Y/140/20/DOC - Further Drainage Comments

From: Paul Cann <Paul.Cann@arun.gov.uk>
Sent: 27 January 2021 15:55
To: Kazys Narbutas Consulting [REDACTED]
Cc: Ian Sellar [REDACTED]; Simon Davis <Simon.Davis@arun.gov.uk>; John Curry [REDACTED]; Alan Kemp [REDACTED]
Subject: RE: Cinders Nursery Phase 2, Cinders Lane: Planning Consent Y/32/17/OUT

Subject: RE: Cinders Nursery Phase 2, Cinders Lane: Planning Consent Y/32/17/OUT

Appendix A Field Work

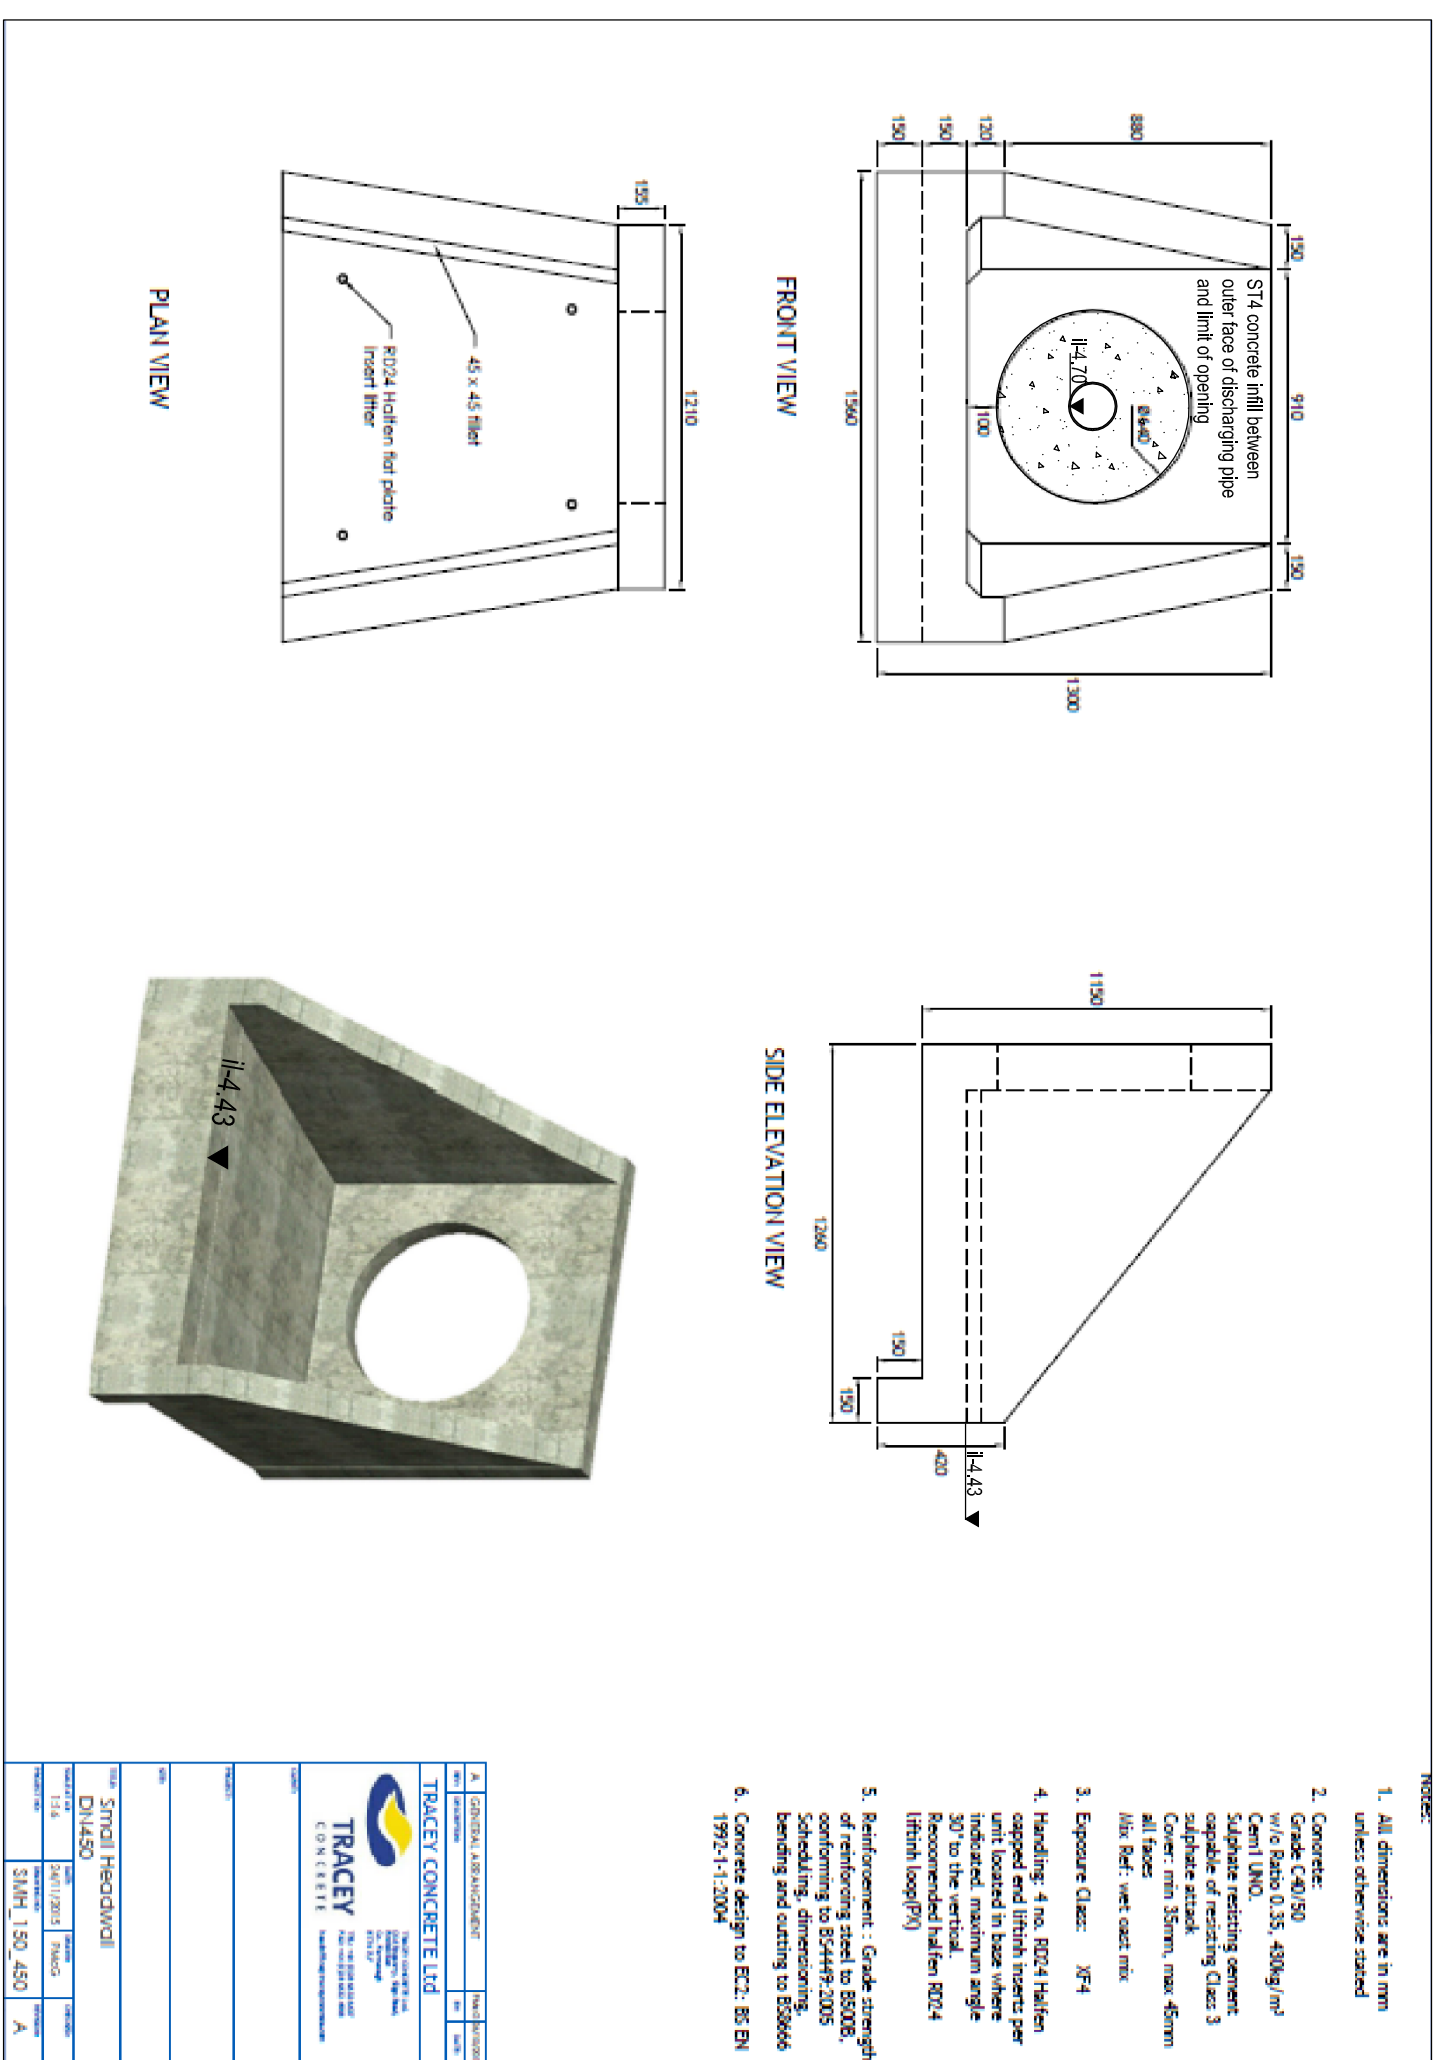
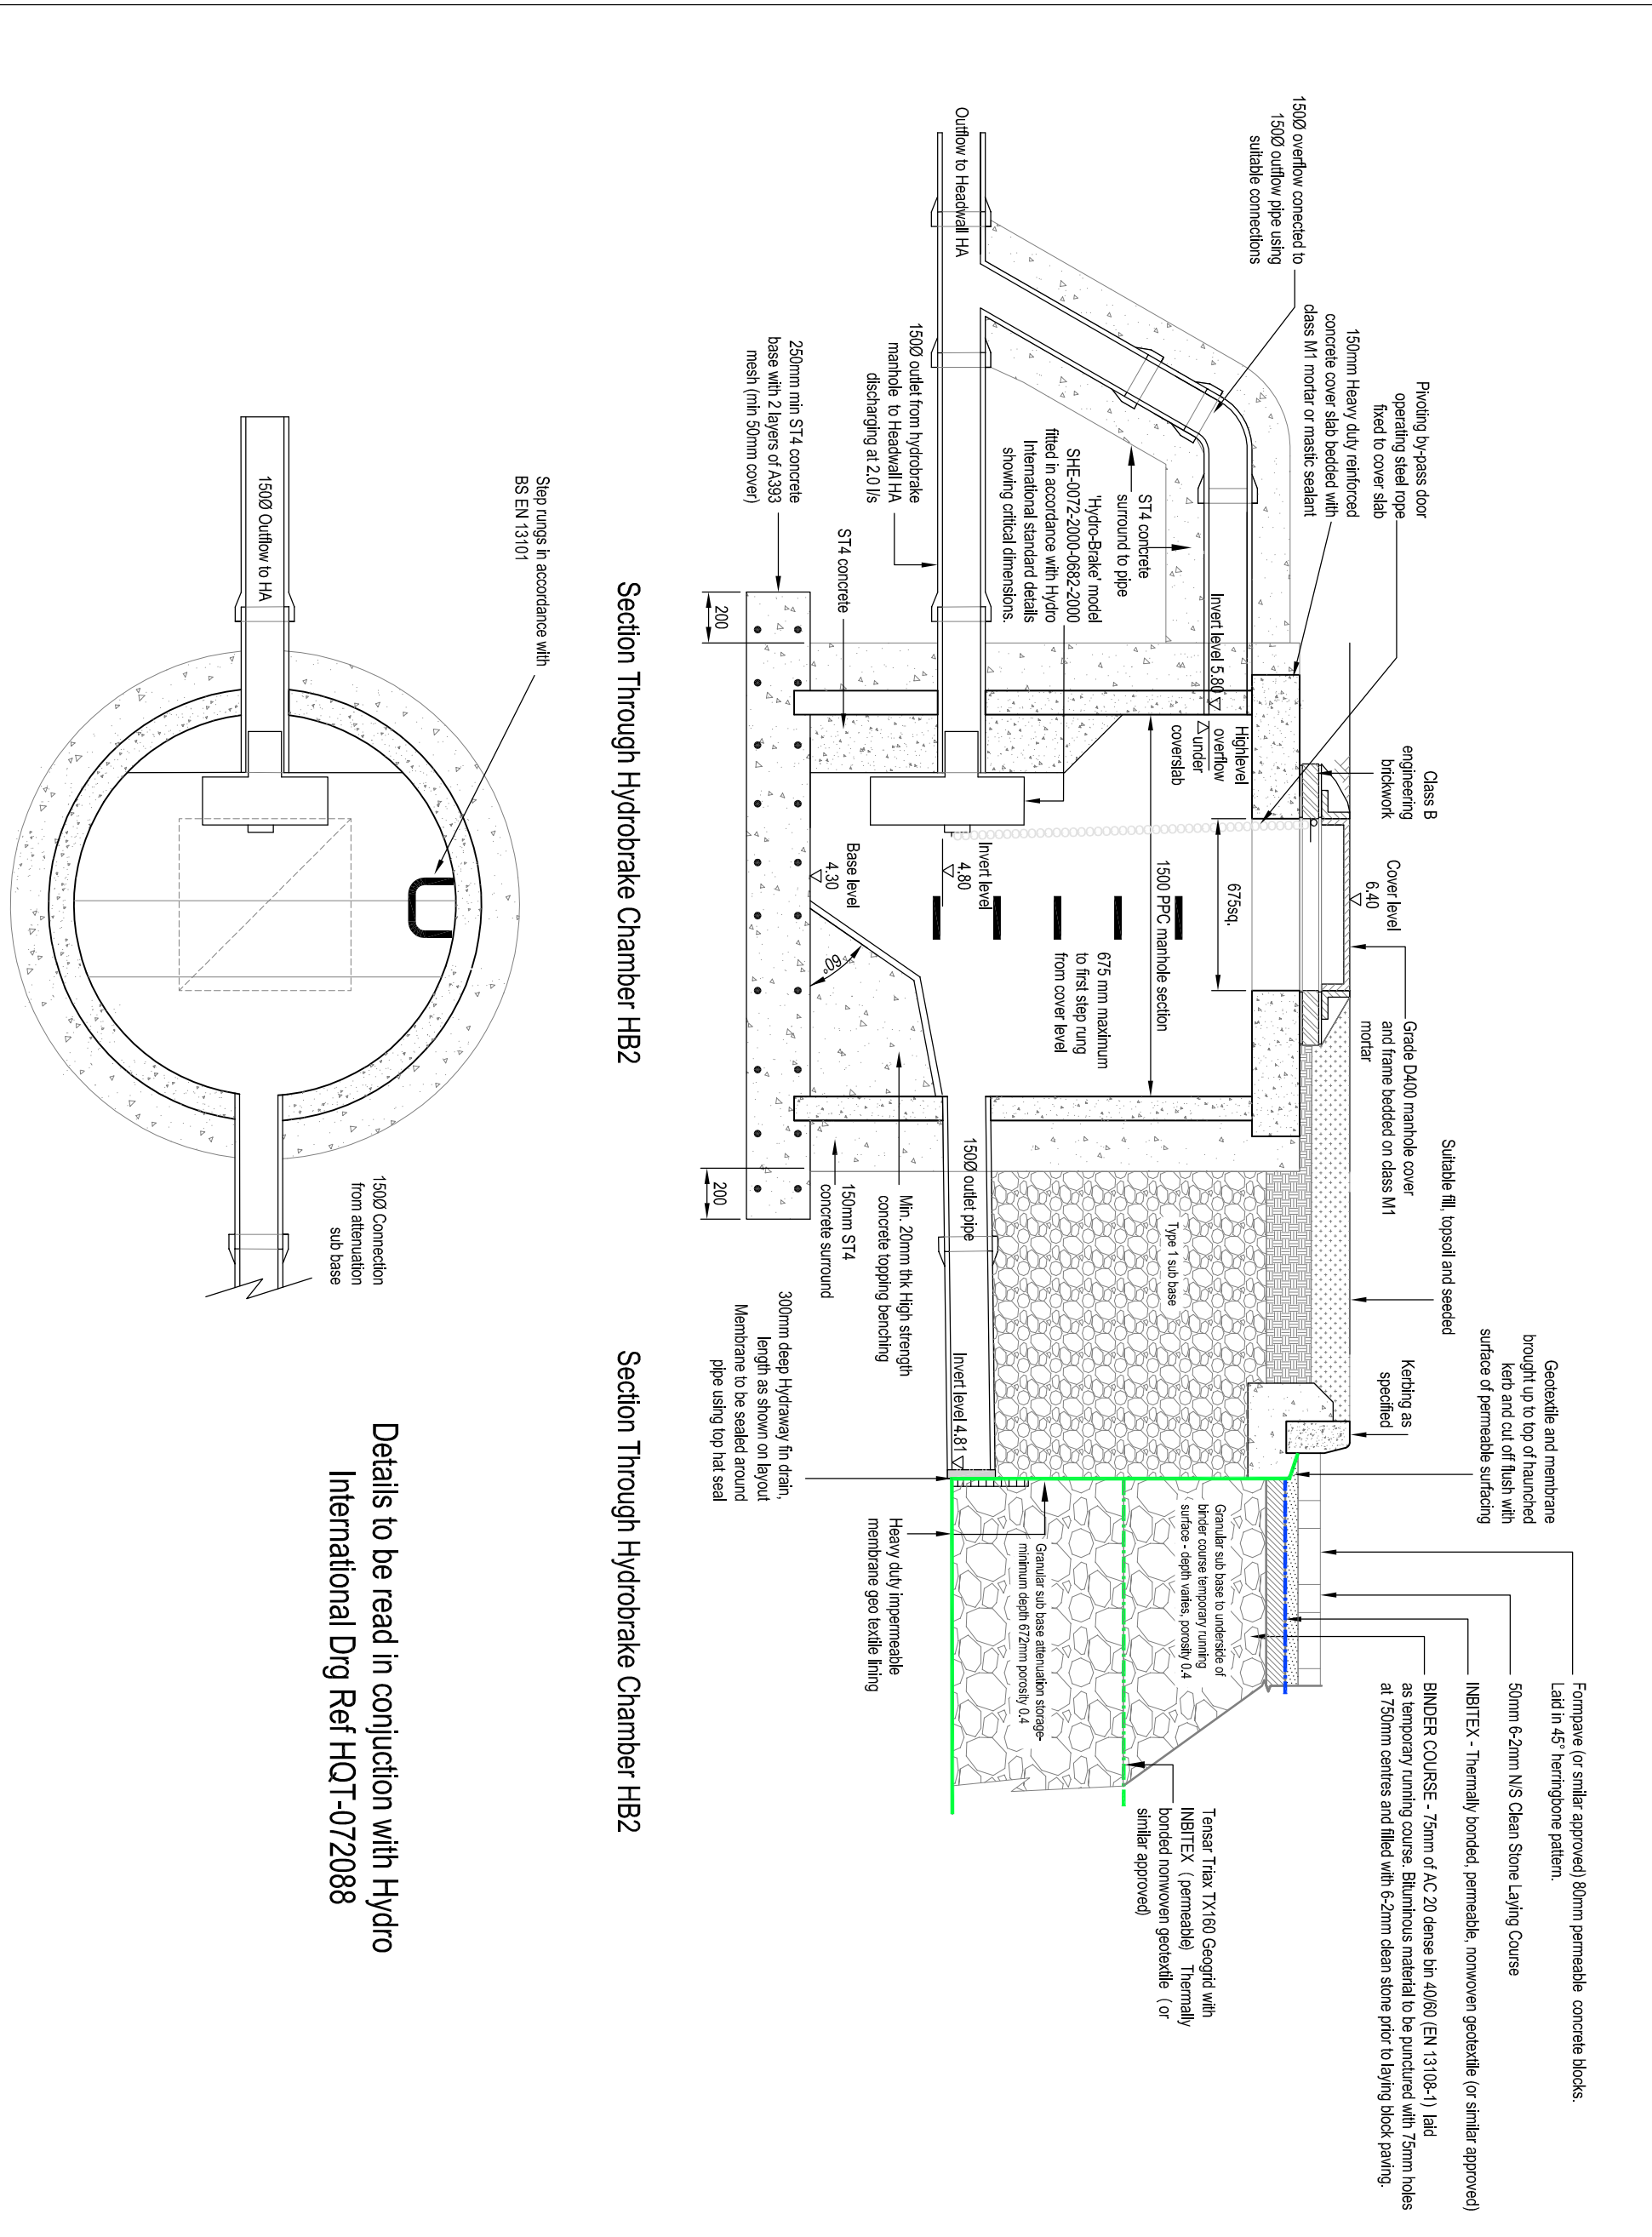
2. Show ditch bed levels at headwall and downstream on plan. Levels shown on drg KNC2006-502-01 Rev F ok
3. Manhole/headwall schedule shows the HA headwall as type H1 – label headwall construction detail as H1. This headwall has now been named H2 to avoid any confusion with other headwalls on the earlier phase. ok

6. Shorten the concrete apron to prevent it extending below the ditch bed. To terminate at the toe of the bank. This will allow the farmer to adjust ditch bed levels as necessary in the future. I have realised that the OWC for the previous phase approved the Tracey Concrete Standard Small headwall which is shown on the approved drawing KNC1826-501-04 Rev D. For continuity I am advocating the use of this headwall for the Phase 2 discharge so I have substituted this for the previously proposed brick construction headwall designated type HA. I trust this meets with your approval. ok
